May 13, 2025

CONDITIONS OF APPROVAL - Project # PR-2025-011387/SI-2025-00040 - Site Plan-EPC

The purpose of this letter is to respond to the Post EPC Memorandum provided by City staff to the DFT, addressing comments on “Unapproved Changes” and Conditions 5-7.

Project No.  
240031-PUNNM

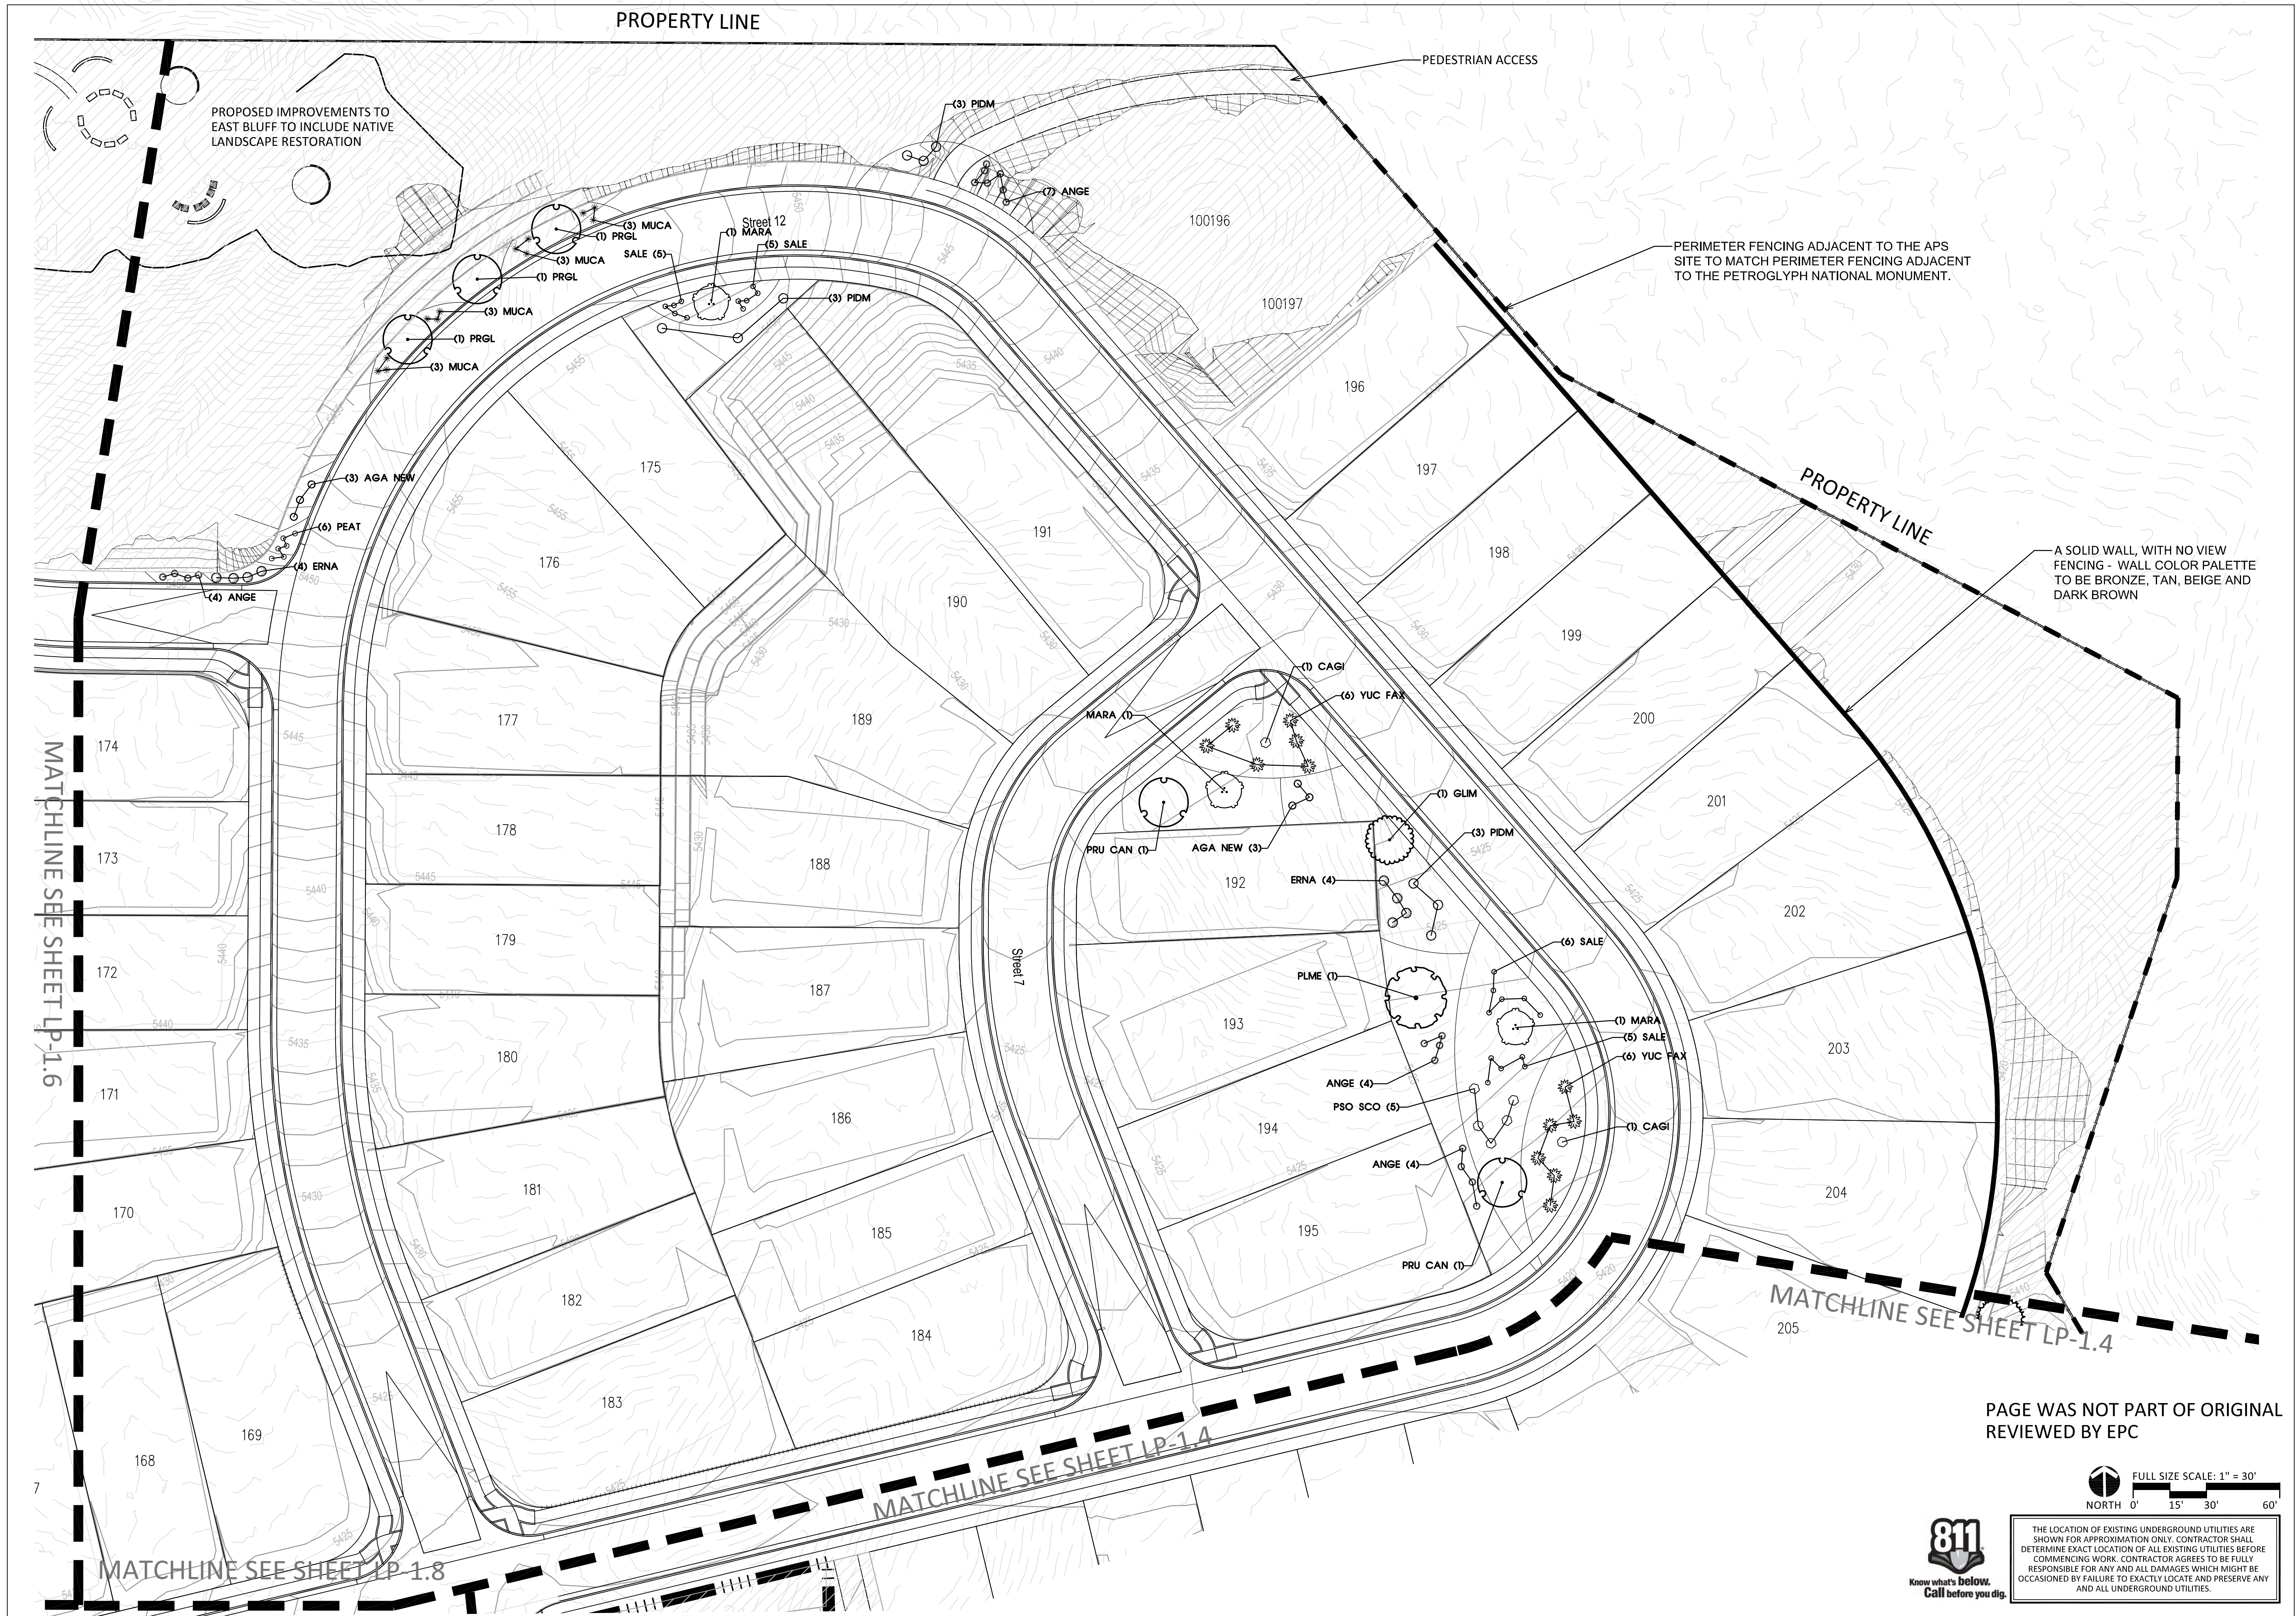
B. A solid wall with no view fencing along Arroyo Vista Blvd NW shall also be noted.

Staff has acknowledged that the applicant provided the “Walls” condition 7B on PLANTING NOTES & PLANT LIST sheet. The solid wall with no view fencing needs to be called out on the Site Plan sheet.

C. For the perimeter wall, a note shall be added that matches the color pallet of the entry gate wall: “overall color palette to be bronze, tan, beige and dark brown with pops of blue and gold accents.”

Staff has acknowledged that the applicant provided the “Walls” condition 7C on PLANTING NOTES & PLANT LIST sheet. The perimeter wall needs to be called out with the above “color palette” note on the Site Plan sheet.

Applicant response: This is called out on Sheets LP 1.1, 1.2, and 1.3.

Applicant response: This is called out on Sheets LP 1.1, 1.2, and 1.3.

3 PROTOTYPICAL CMU WALL  
SCALE: 1/2" = 1'-0"

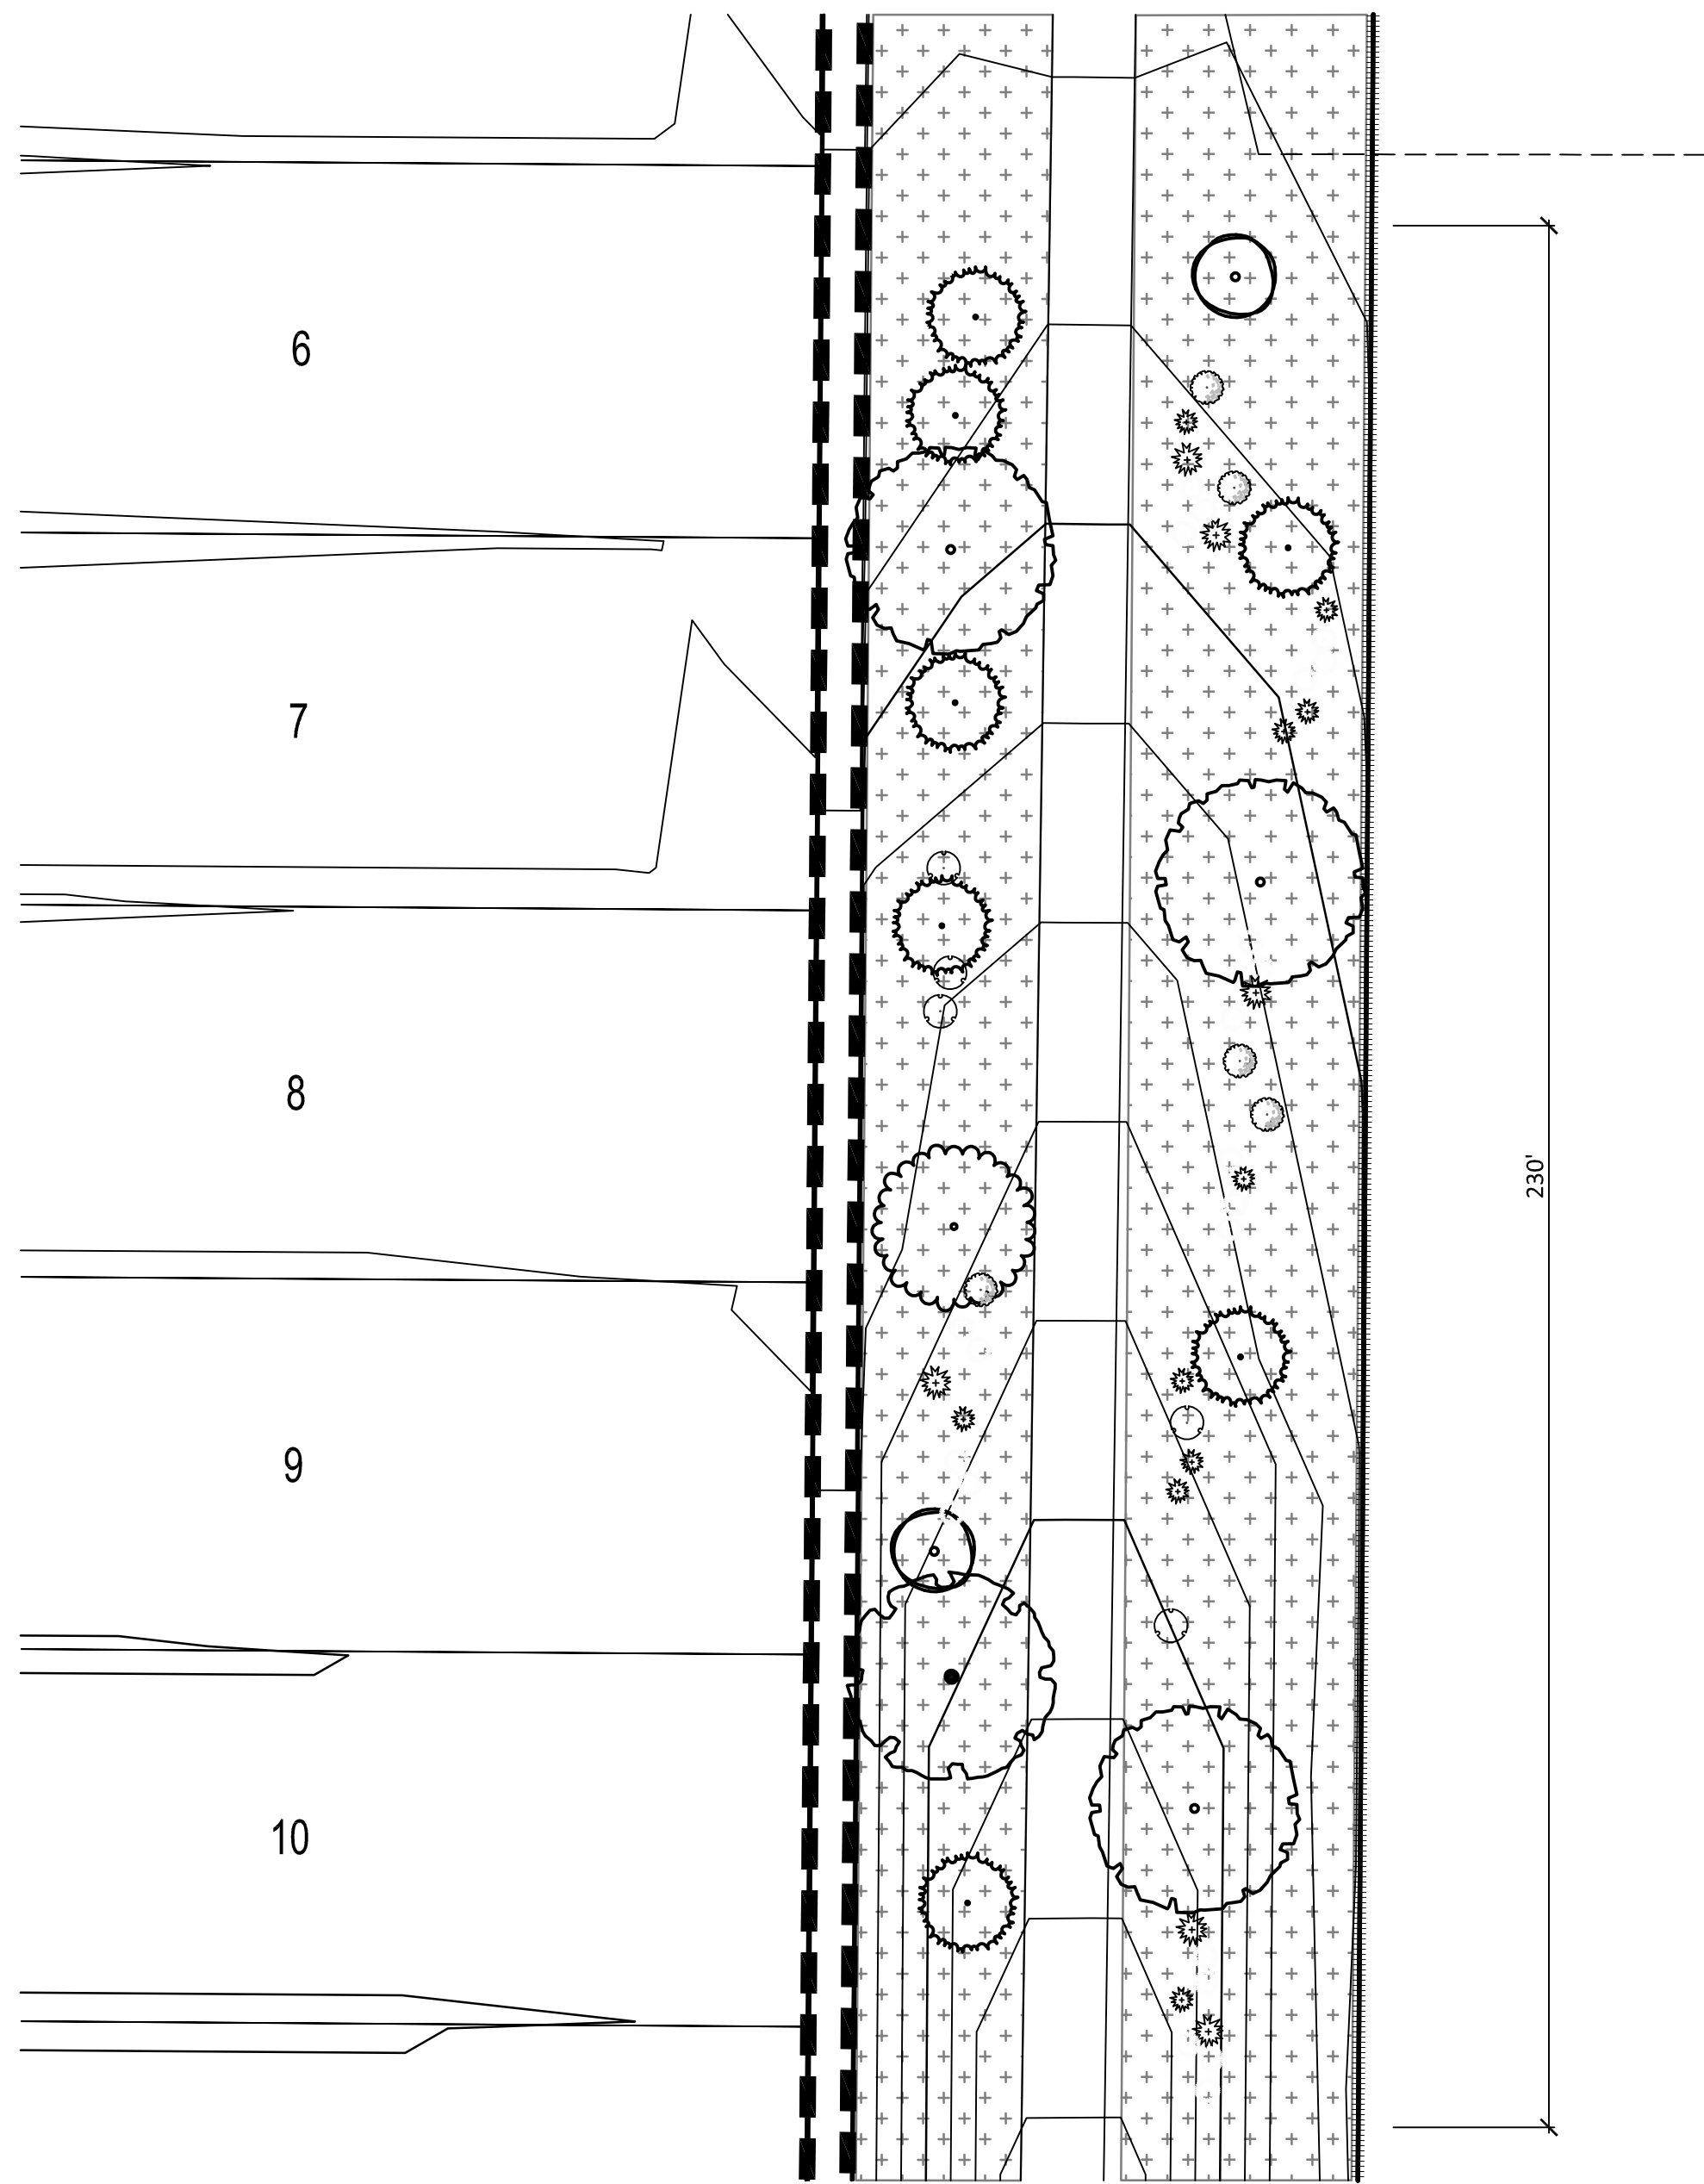
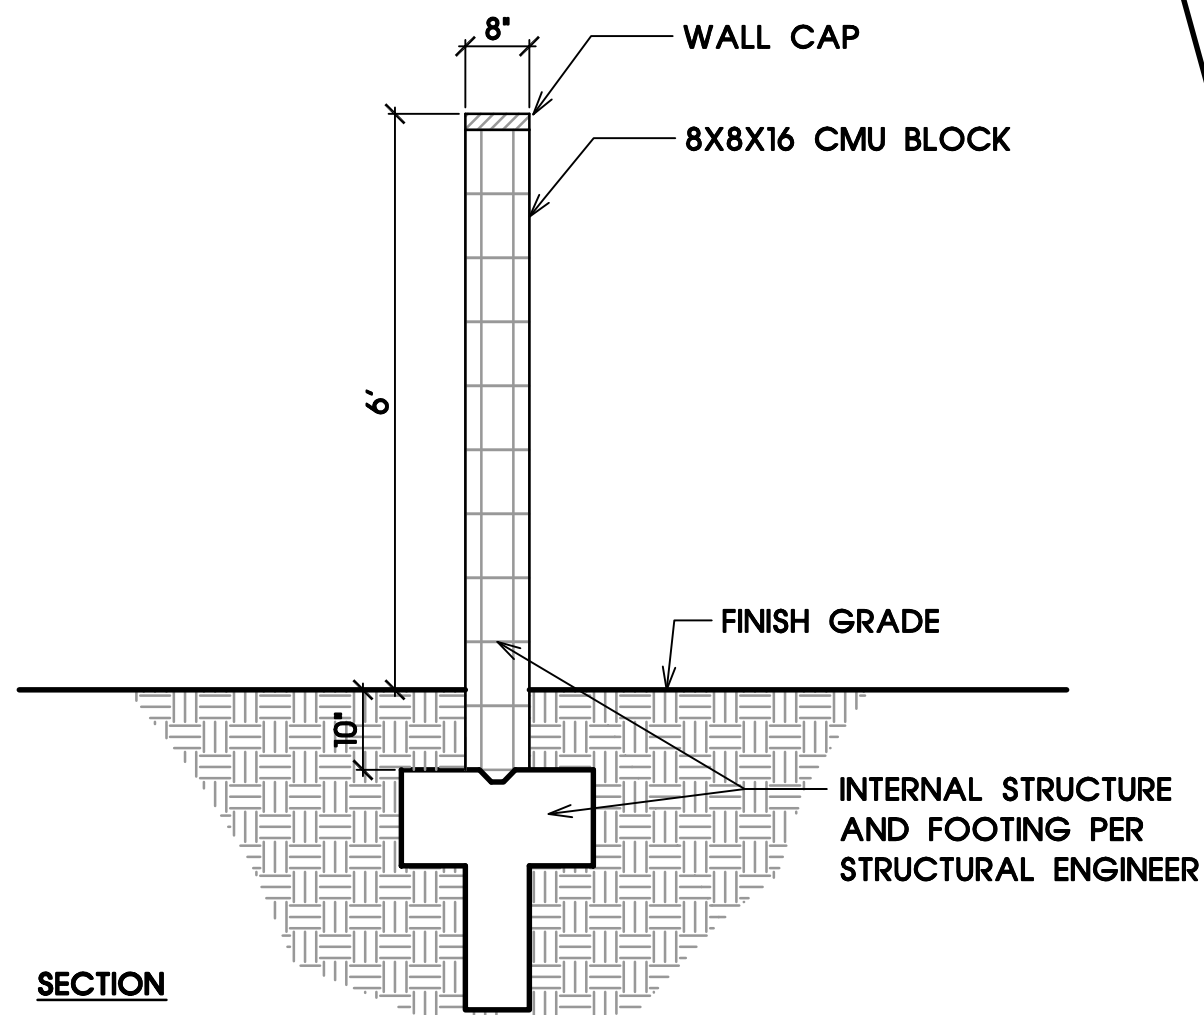
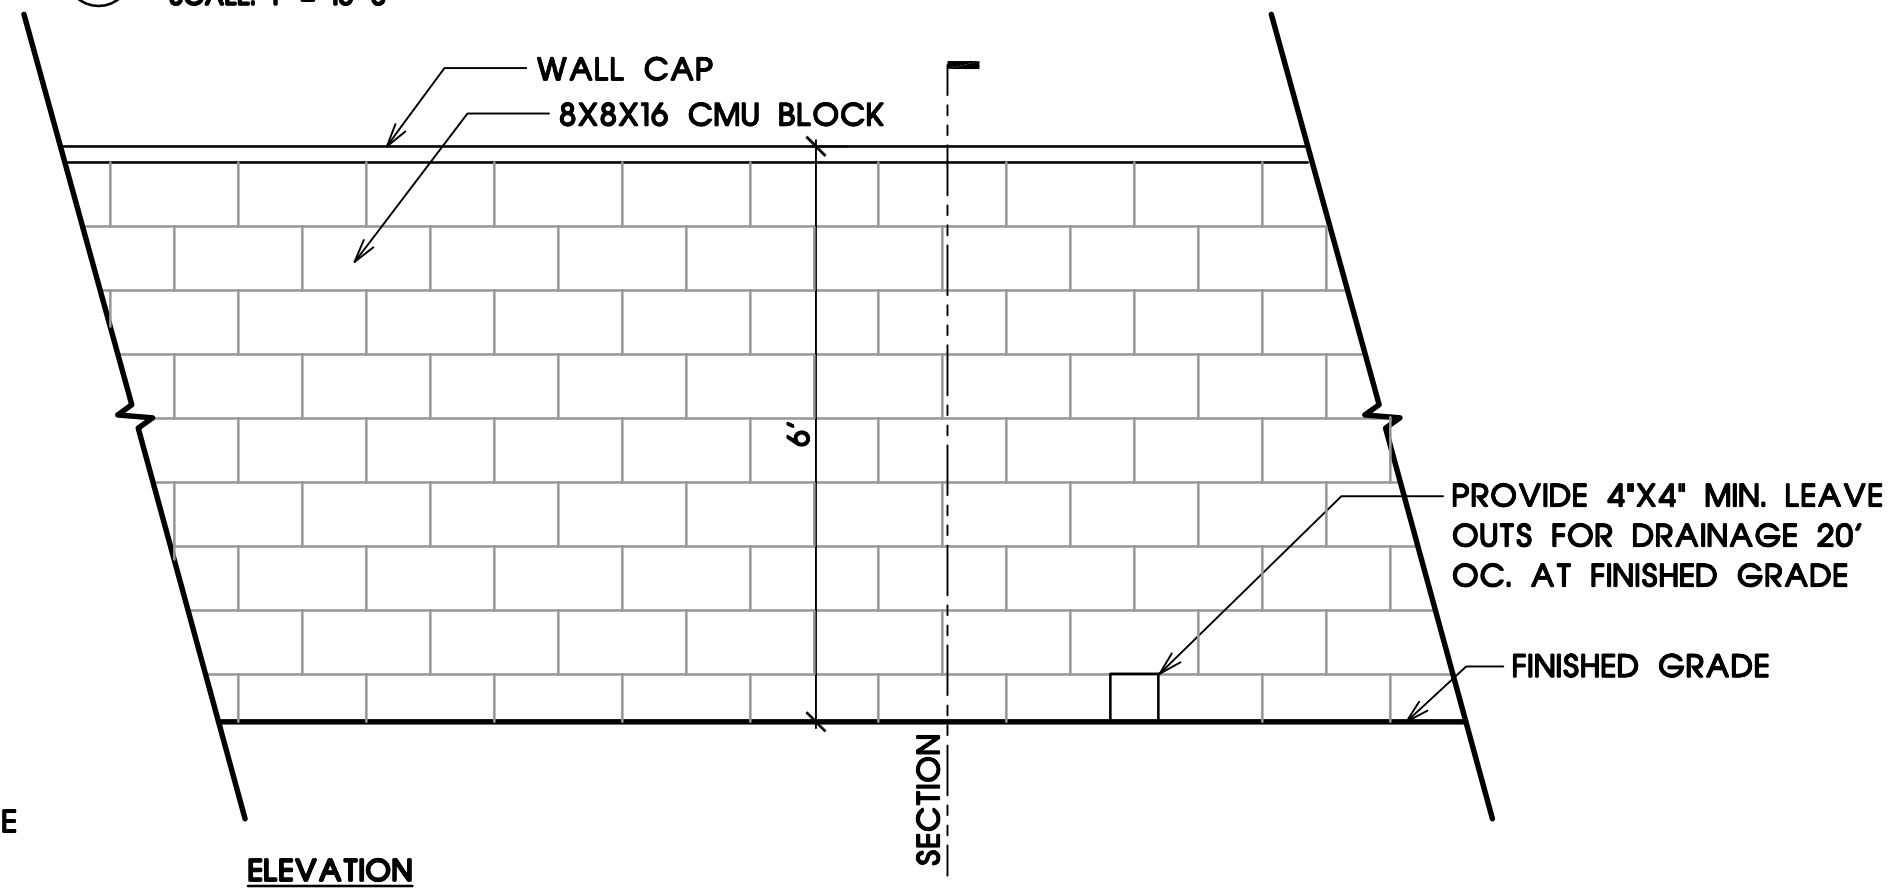
A. A detail of the fencing adjacent to the open space requested by the National Park Service and the wall adjacent to the ABQ Public School shall be provided that notes: perimeter walls adjacent to the open space and APS to be constructed with a lower CMU portion and view fencing on top. The applicant shall work with the National Parks Service on finalizing fence design details along the Monument boundary.

1) A detail is missing depicting the fencing adjacent to the open space. Please add this detail.

2) A detail is missing of the wall adjacent to ABQ Public School. Please add this detail.

Applicant response: A detail depicting the fencing adjacent to the open space has been added. Perimeter walls adjacent to the open space and APS will not be constructed with a lower CMU portion and view fencing on top. Rather, the National Parks Service prefers and agrees to 5'-6' steel wire mesh (hog wire) on wooden posts. See attached correspondence.

Applicant response: A detail depicting the fencing adjacent to APS has been added. Perimeter walls adjacent to the open space and APS will not be constructed with a lower CMU portion and view fencing on top. Rather, APS deferred to the National Parks Service's preference. See attached correspondence.
